Office of
Environment
& Heritage

Your reference: SSD4978
Our reference: DOC14/133706
Contact: Richard Bonner, 9995 6917

I refer to your email of 9 July 2014, seeking comments from the Office of Environment and Heritage (OEH) on the Tinda Creek Sand Extraction State Significant Development (SSD 4978) proposal.

Office of Environment and Heritage (OEH) comments on the Tinda Creek Sand Extraction State Significant Development proposal

Figure 4.1 - Proximity of Project Area to World Heritage Area and National Park

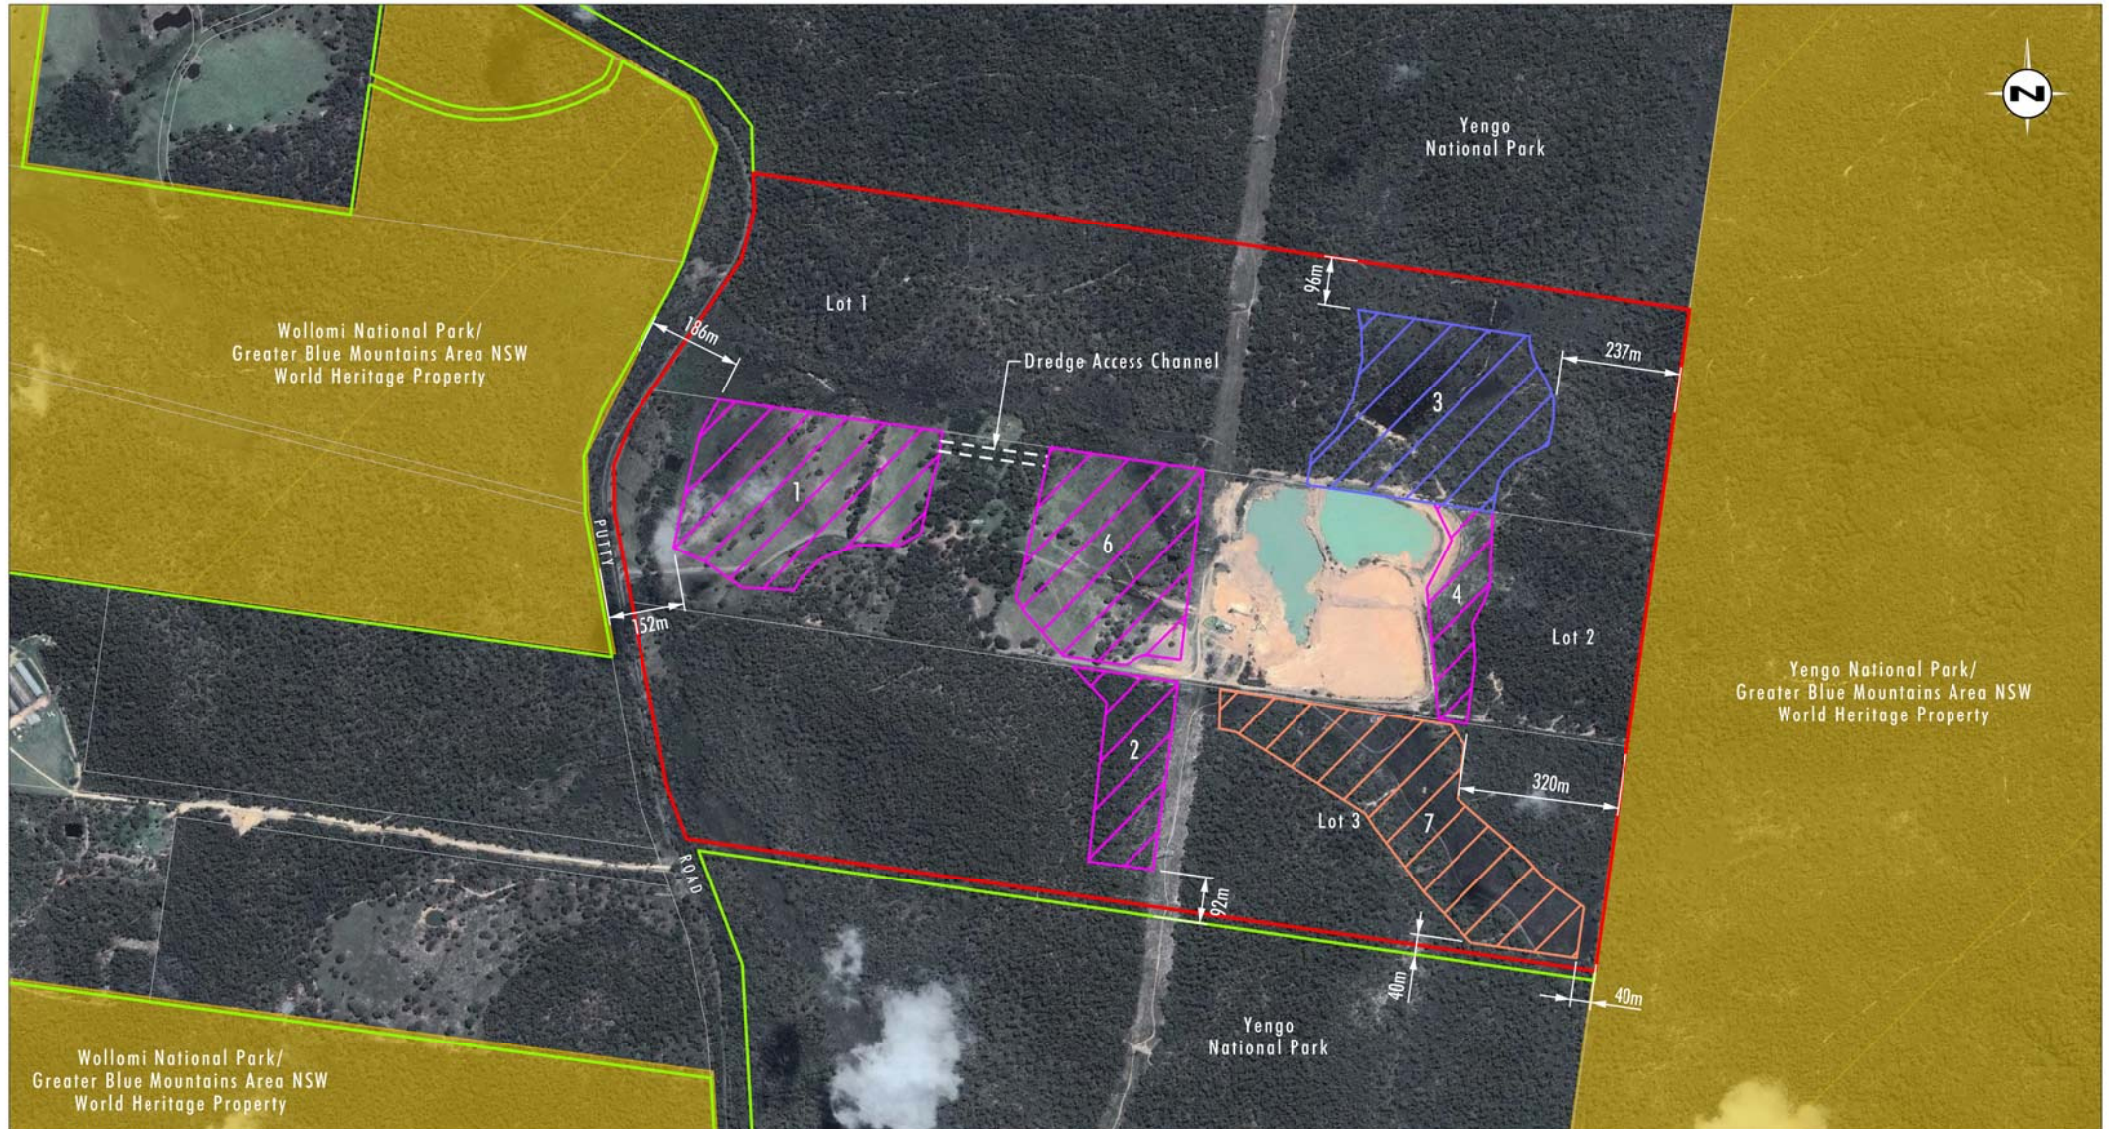
In addition, OEH notes the statement at 4.9 of the EIS that extraction operations will be setback from the Greater Blue Mountains World Heritage Area (GBMWH) by 'a minimum of 237 m' and Yengo National Park (YNP) by '40m if domain 7 is quarried' which does not correlate with figure 4.1 indicating a 14m setback. The potential impacts on the values of the GBMWH and YNP arising from this significantly reduced setback have not been addressed in the EIS.

OEH recommends the setback of proposed operations from the GBMWH and YNP be clarified. Extractive operations should be restricted by way of an appropriate buffer to ensure the values of these areas are not impacted.
